To: All Staff
From: Environmental Health
Date: 2/05/2026
Subject: BL-26-00001

RECORD OF SURVEY

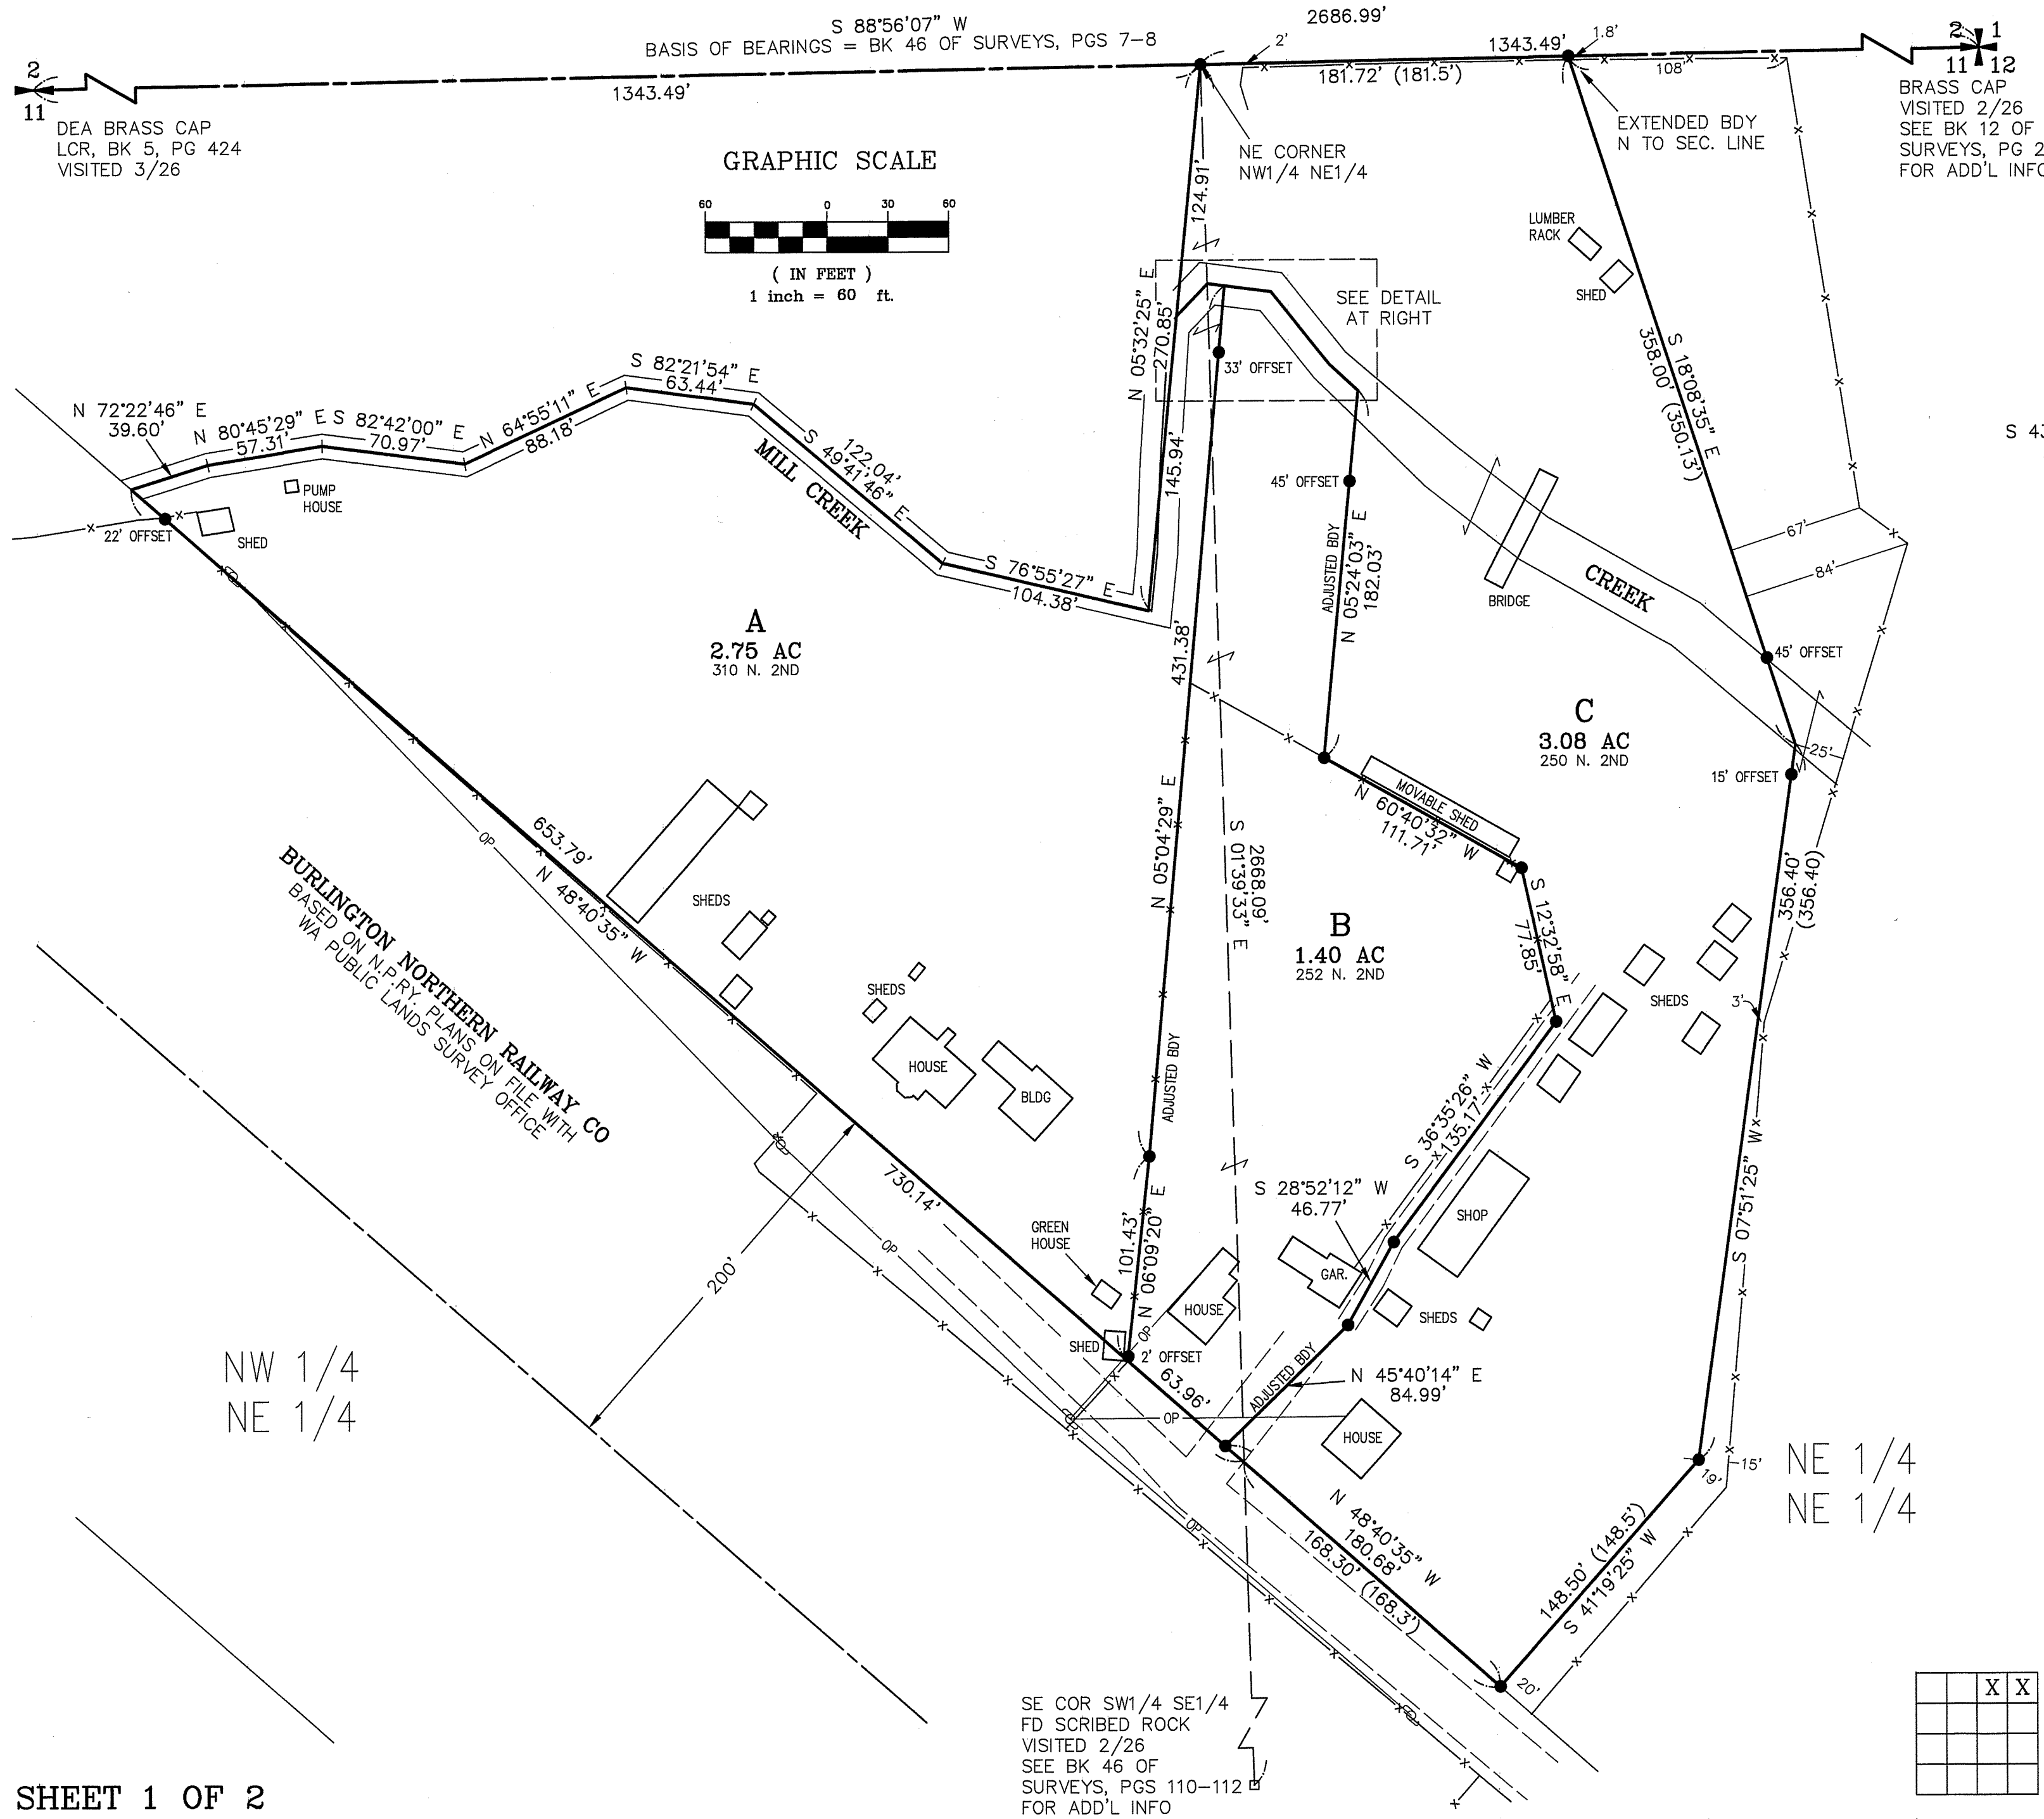
Drinking Water	<ul style="list-style-type: none">• No Comment
Wastewater	<ul style="list-style-type: none">• KCPHD recommends maintaining property line / easement setbacks of five feet from new and existing septic systems shown in WAC 246-272A-0210 Table IV• KCPHD recommends a Site Evaluation be conducted on lot B to verify soil type in regard to minimum land area requirements WAC 246-272A-0320 Table XI
